**Your ref:** 3/2016/0027  
**Our ref:** DC/16/365  
**Date:** 22-FEB-16

**Location : Bowland wild Boar Park, Wardsley Rd, chipping, PR3 2QT**  
**Proposal: cou of field to create campsite for 5 camping pods, toilet & shower building**

PROPOSED SITE
PLAN

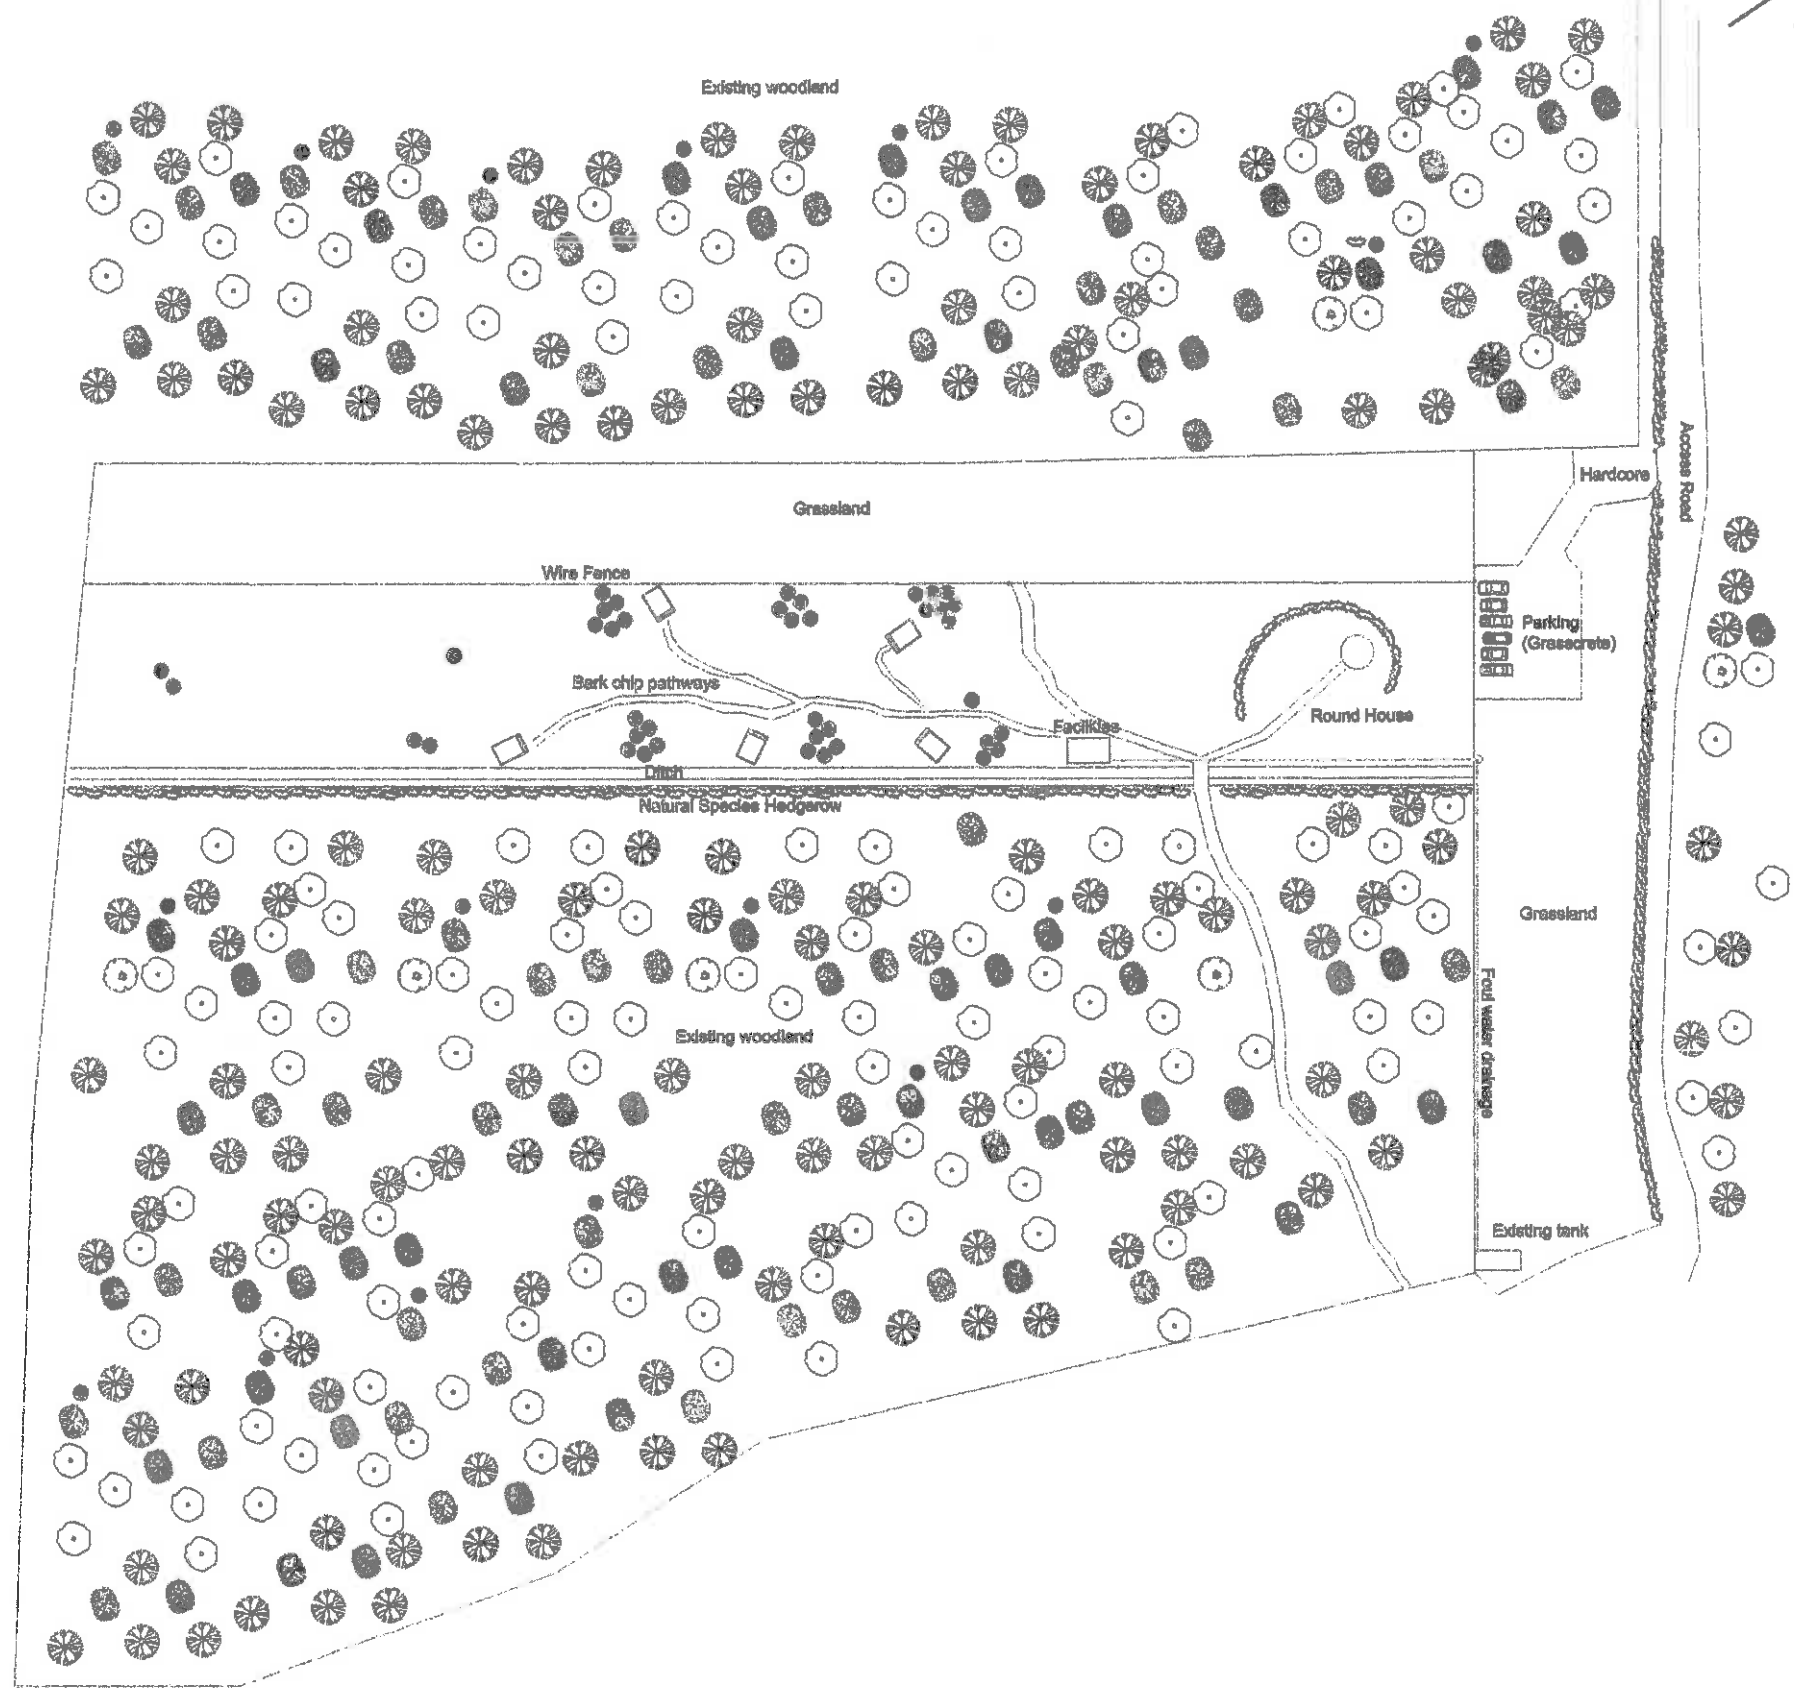
**Large diameter raw water mains cross the site. As we need access for operating and maintaining them, we will not permit development in close proximity to the mains. You will need an access strip of no less than 10 metres, measuring at least 5 metres either side of the centre line of the pipes. The applicant must comply with our standard conditions, a copy of which is enclosed, for work carried out on, or when crossing aqueducts and easements. This should be taken into account in the final site layout, or a diversion will be necessary, which will be at the applicant's expense. Any necessary disconnection or diversion required as a result of any development will be carried out at the developer's expense. Under the Water Industry Act 1991, Sections 158 & 159, we have the right to inspect, maintain, adjust, repair or alter our mains. This includes carrying out any works incidental to any of those purposes.**

**According to our records there are two easements (R370a dated 14/06/1934 and R377 dated 28/06/1877) that run adjacent and through the proposed development site. Under no circumstances should anything be erected, planted or stored over the easement width, nor should anything occur that may affect the integrity of the pipe or United Utilities legal right to 24hr access. I would also advise that the developer adheres to the standard conditions for works adjacent to pipelines guidance as there is a main water pipe crossing the site.**
